CITY OF ALBUQUERQUE

August 13, 2021

**Re: Mountaintop Extracts
1912 1st St. NW 87102
30-Day Temporary Certificate of Occupancy
Transportation Development Final Inspection
Engineer's/Architect's Stamp dated 1-7-21 (H14D113)
Certification dated 8-9-21**

1 HANDICAP PARKING SIGNS

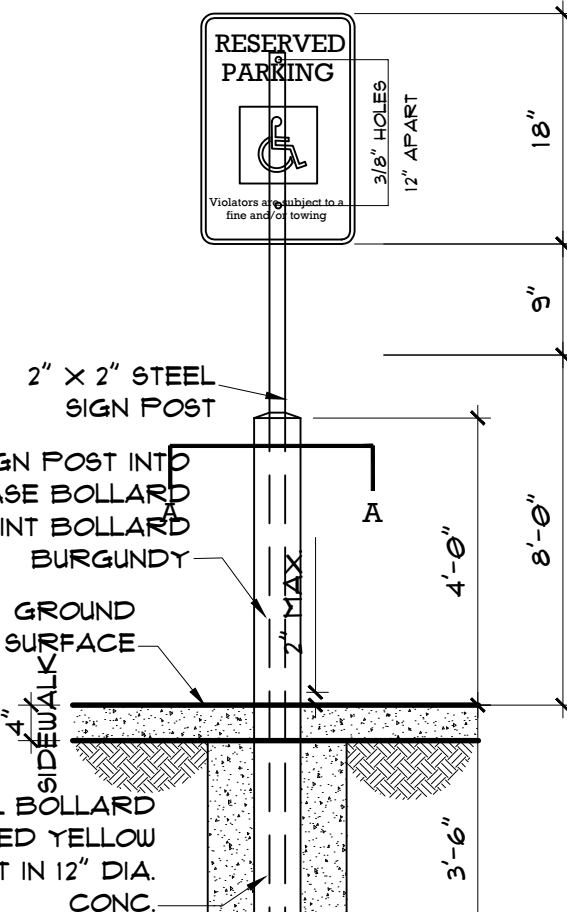
- Please send pictures of the Bike Rack and ADA Signage.
